DECISION DELEGATED TO HEAD OF PLANNING

Application No: H08-0045-25 **Applicant:** 713 Homes Ltd

Proposal: Details of external materials, existing and proposed site levels, proposed floor levels, landscaping, tree planting, proposed boundary treatments, surface water disposal, foul water disposal and Biodiversity Net Gain Plan (Conditions 3, 5, 6, 7, 8, 9 and 10 of H08-0183-24)

Location: Adj 3 Bow Gate Gosberton Spalding

Scale: 1:10, 1:50, 1:100, 1:200, @ A1 Drawing: AWM Checked: TAC Date: 10/01/2025 Drawing No: 24/673/PA/001

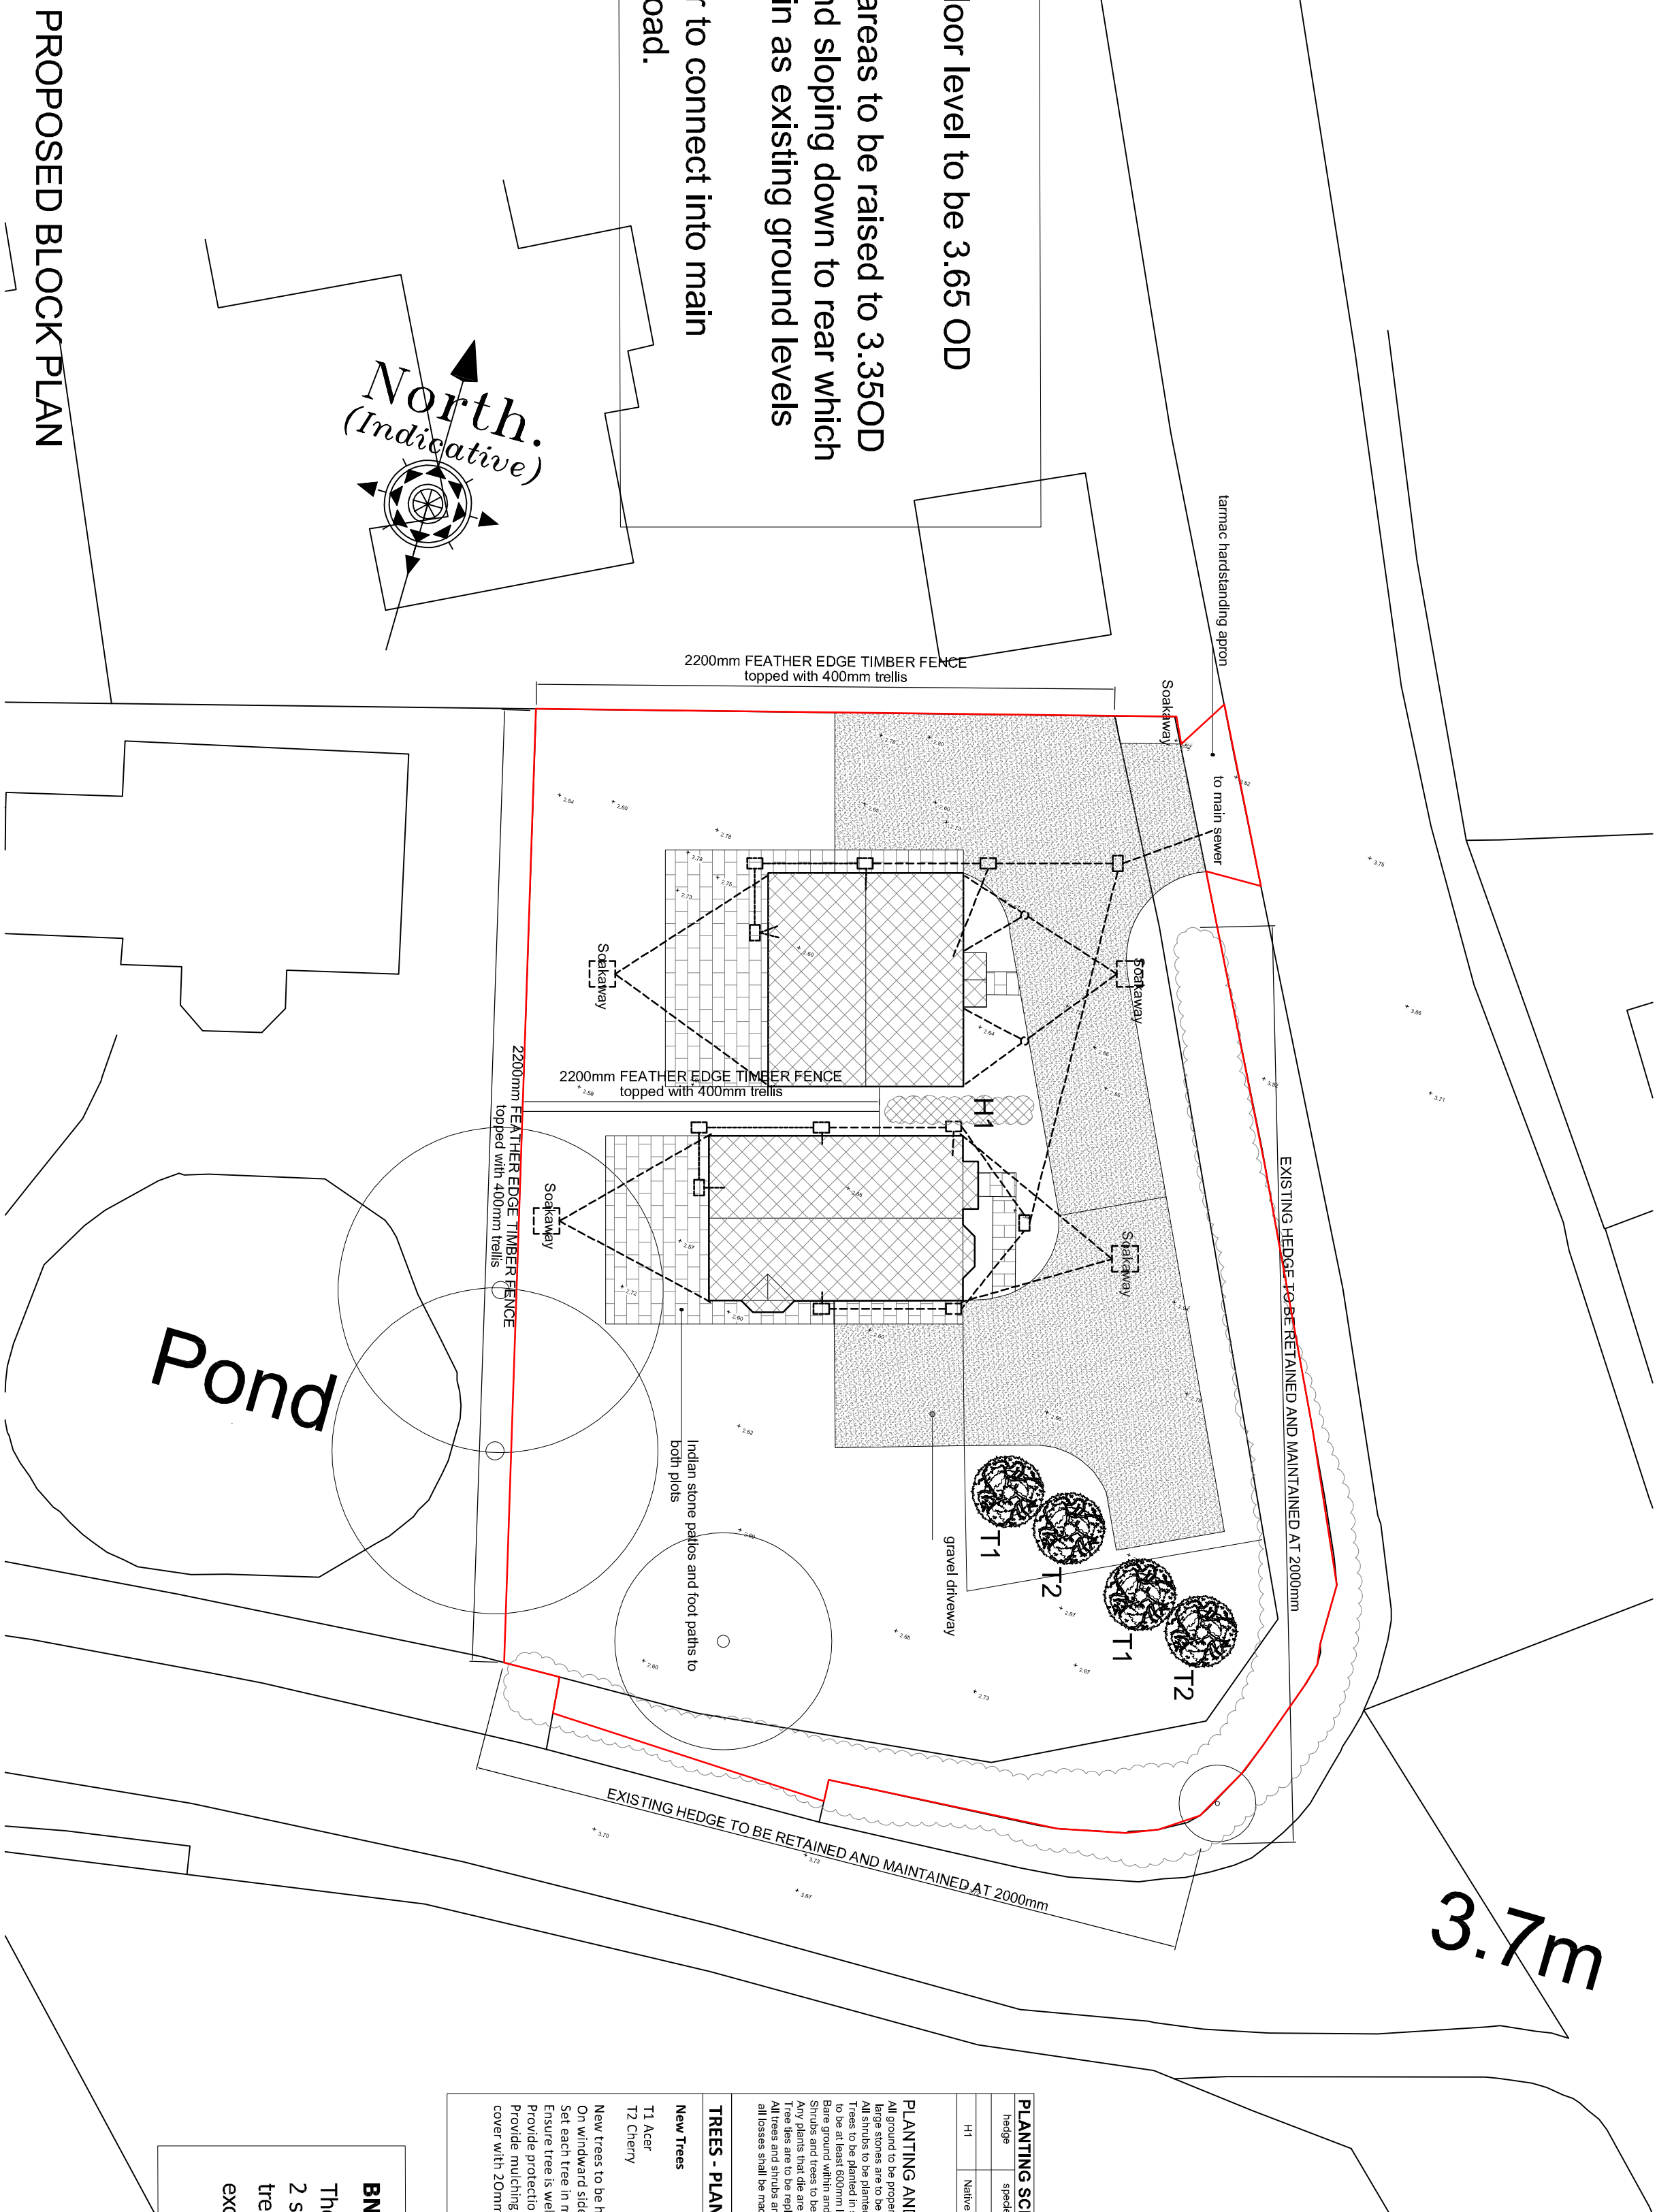
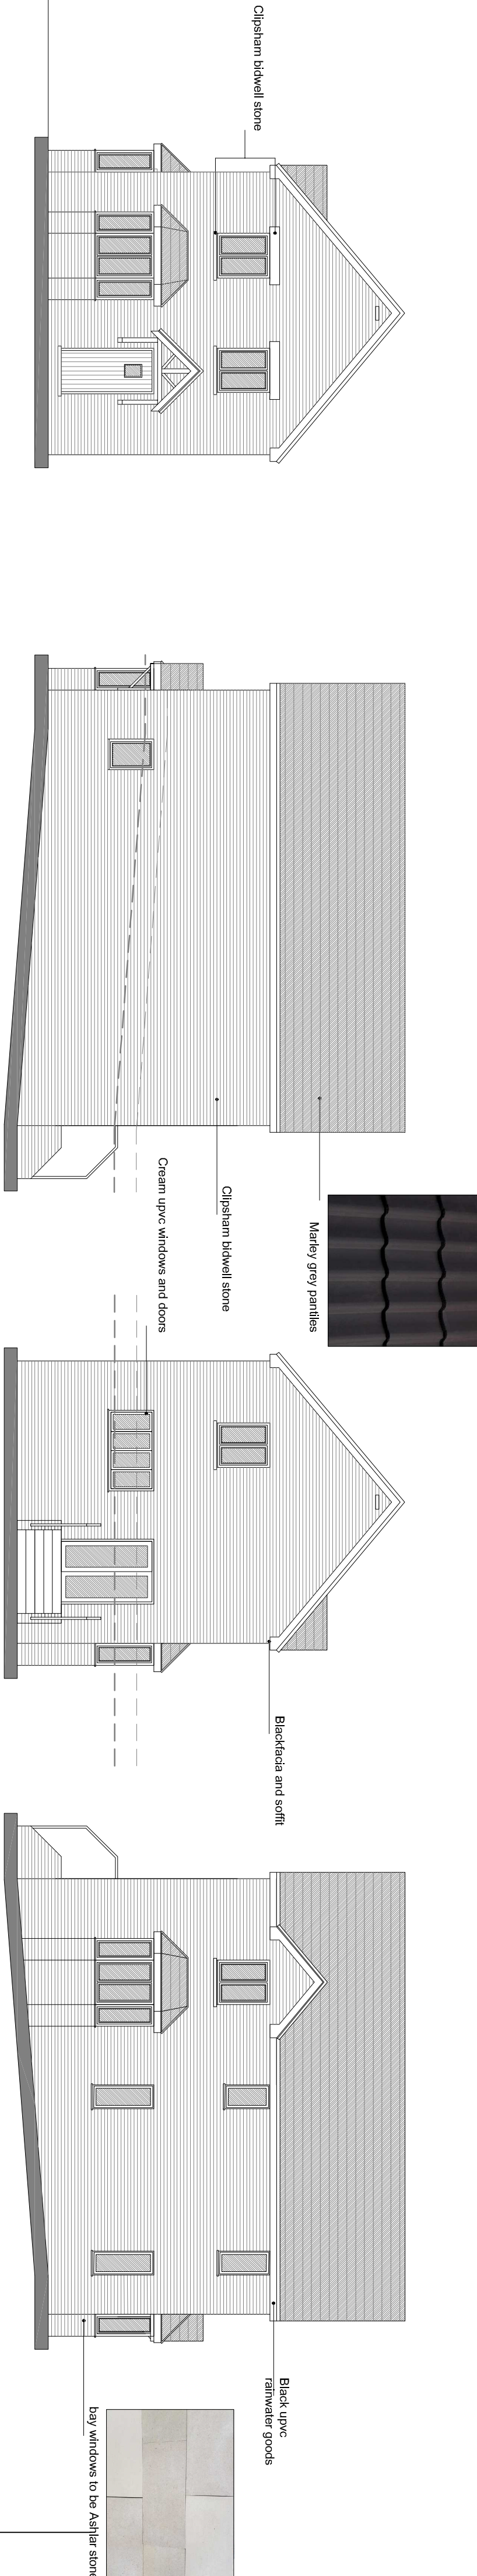
It is considered that Clipsham Stone is an inappropriate material in this setting. The dwellings in the area are primarily constructed from fairly red brick, with some yellow/ grey bricks interspersed. To this end, the use of stone would be an outlier, which fails to respect the character and appearance of the setting.

The condition explicitly requires cross section drawings to be submitted, which have not been provided here. In addition, to provide a thorough assessment of the potential impacts, a more detailed topographic study would be required.

From the details provided, it would appear that limited planting has been proposed. It would appear the landscape is principally four trees (two acer and two cherry) and a short hedge between dwellings. This is not considered sufficient to provide a clear net gain, and insufficient evidence has been provided to the contrary.

No cross sections have been provided, or elevation drawings to show how the fence will actually look. As such, it is considered that insufficient information has been provided to discharge the condition.

Four soakaways are proposed (two to the rear and to the front); however, no details of their capacity or scale have been provided. As such, it cannot be assured that the strategy is acceptable; and therefore, the condition cannot be discharged.

In addition to the hedge and trees, two swift bricks per dwelling are proposed. For swift bricks to function effectively, they should be in threes; therefore, rendering the strategy ineffective.

The condition also required details of management and monitoring which have not been provided.
